## Stop the West Midlands Interchange

### 5<sup>th</sup>/6<sup>th</sup> June Post Hearing Submissions

#### Site Wide Travel Plan April 2019

TITLE:  
**PROPOSED DIRECTIONAL SIGNAGE**

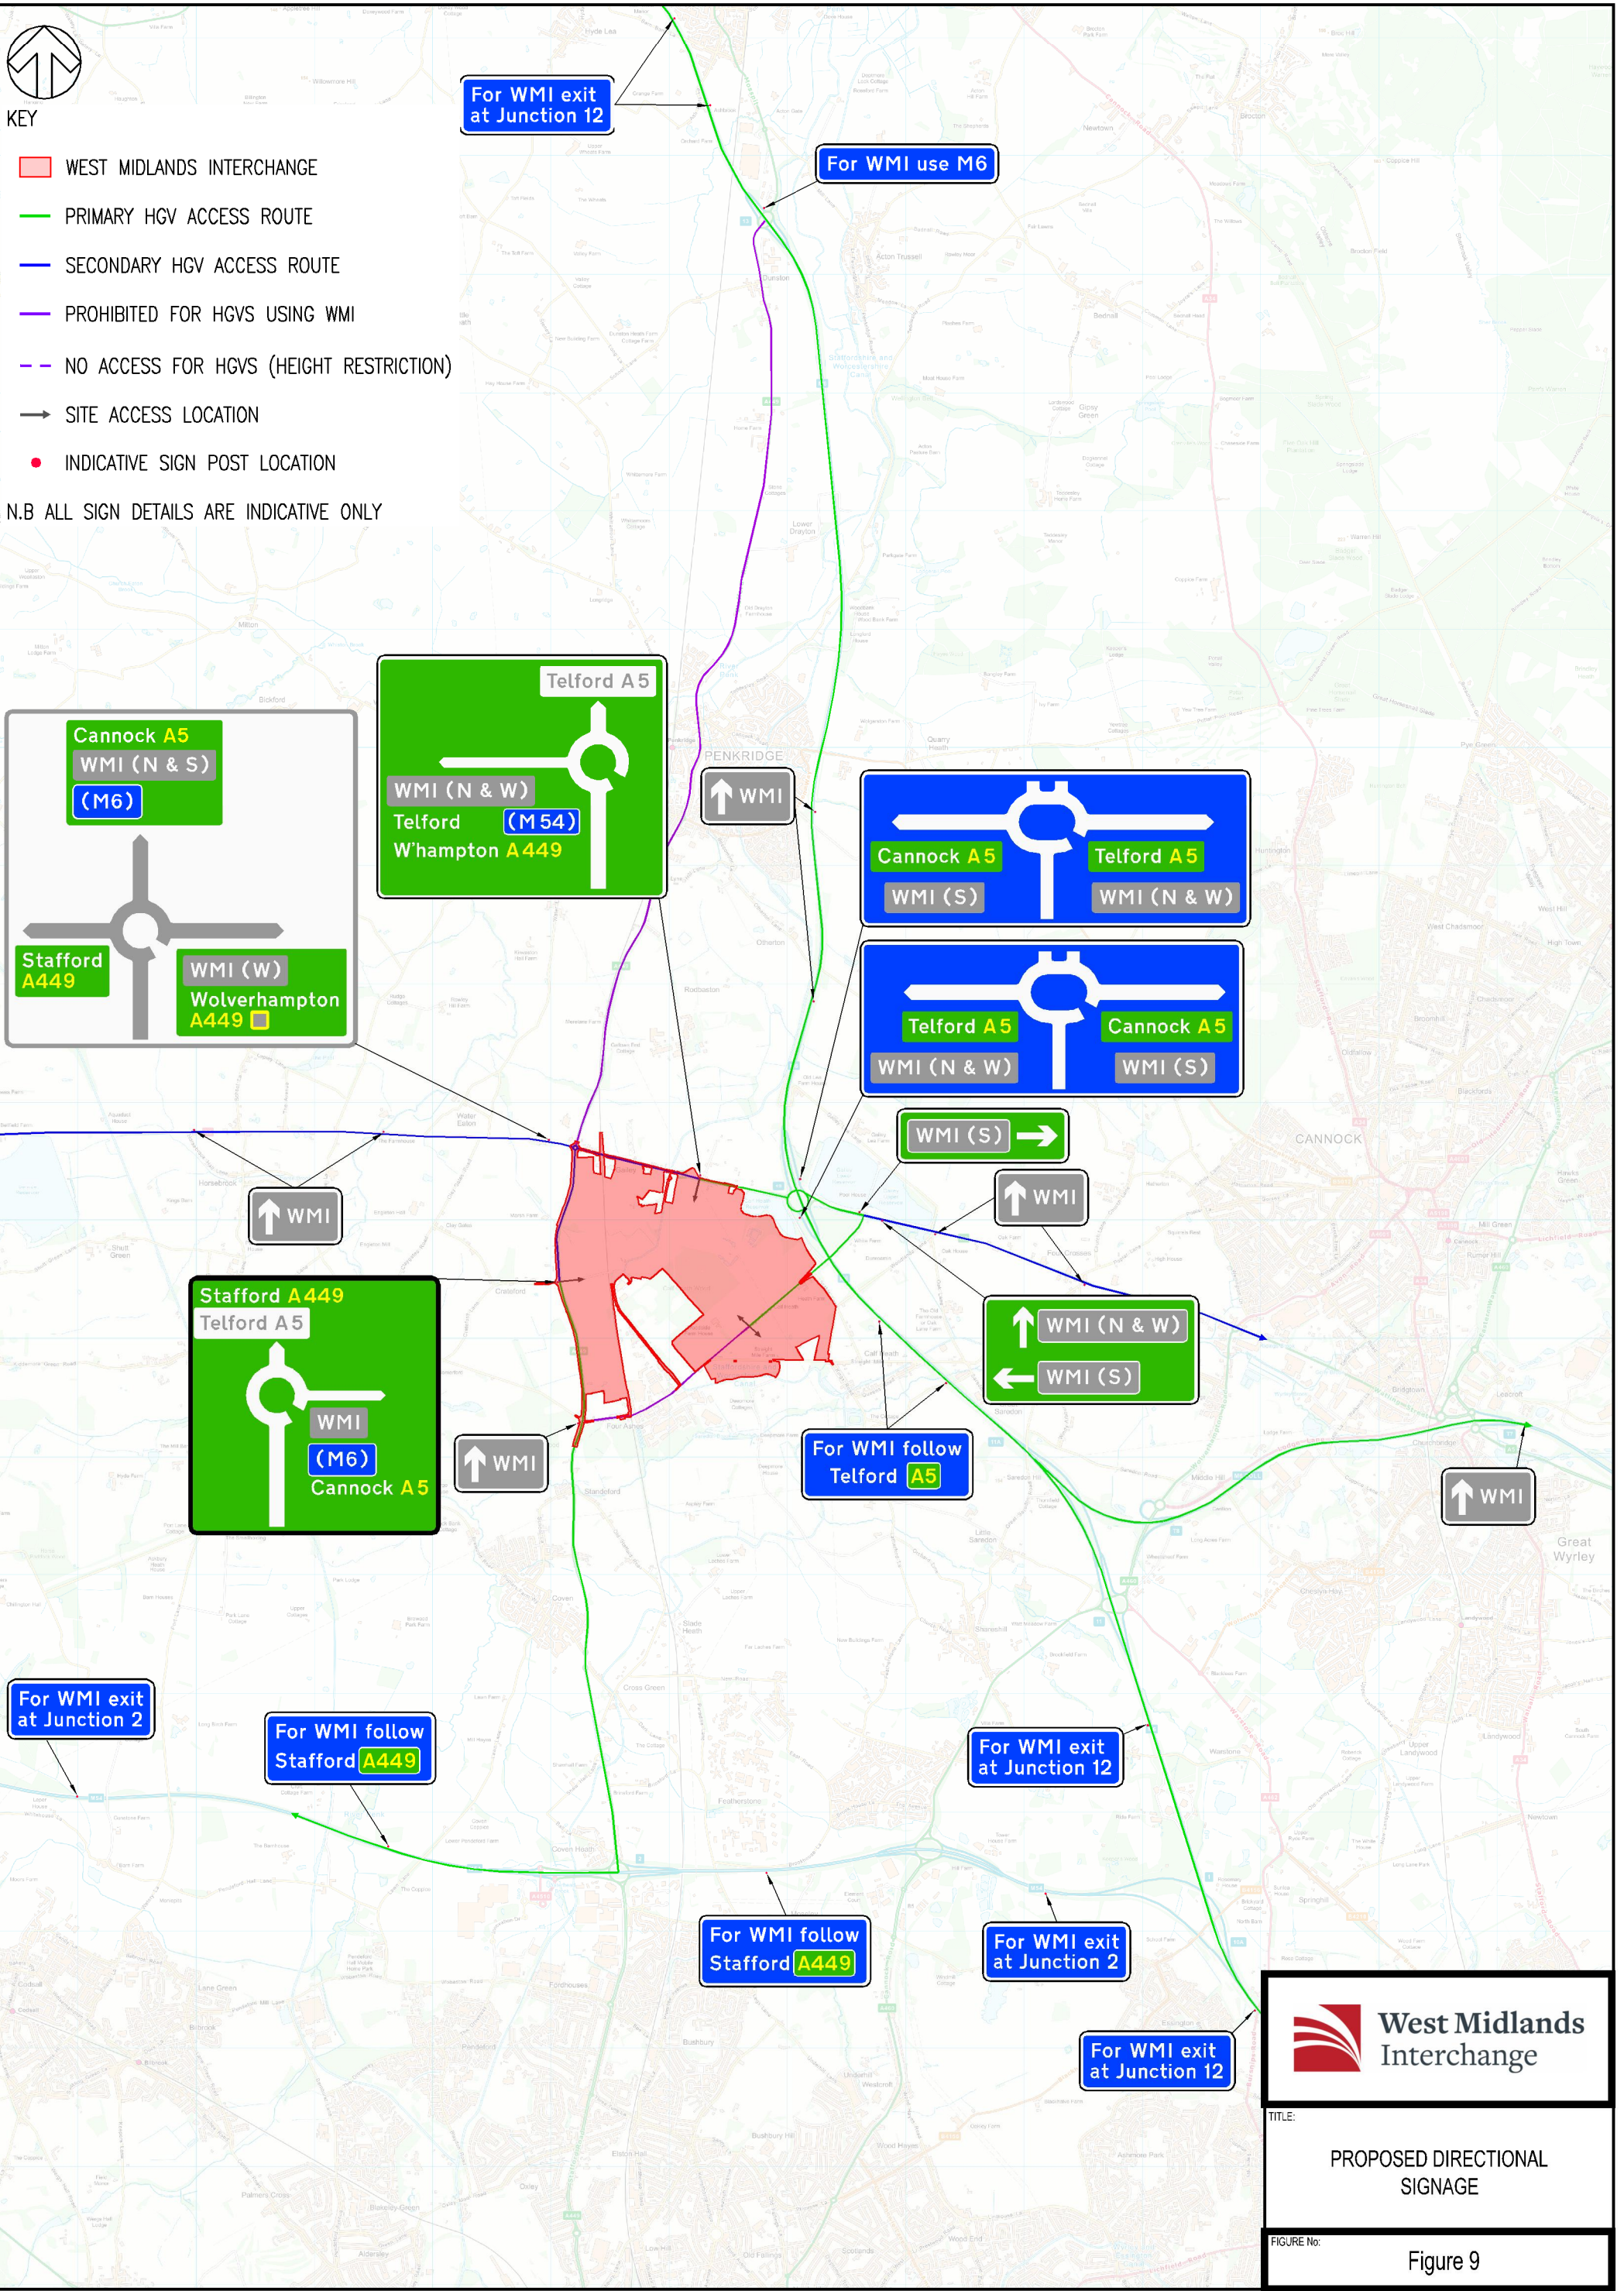
**Groups Response:** This is utterly ineffective. During SRN closures HGVs routinely ignore signage and follow their sat navs. The roads around Crateford are used as rat runs, a situation worsened by the traffic signals introduced at Four Ashes and Crateford.

**5.4.8** Drivers will be informed to follow the strategic directional signage which is proposed to be introduced from the M6 and M54 to ensure drivers remain on the strategic road network. This will be complimented by signs on the A5 and A449 which will be located prior to minor road access, to ensure driver confidence and deter any potential 'rat running' through minor roads.
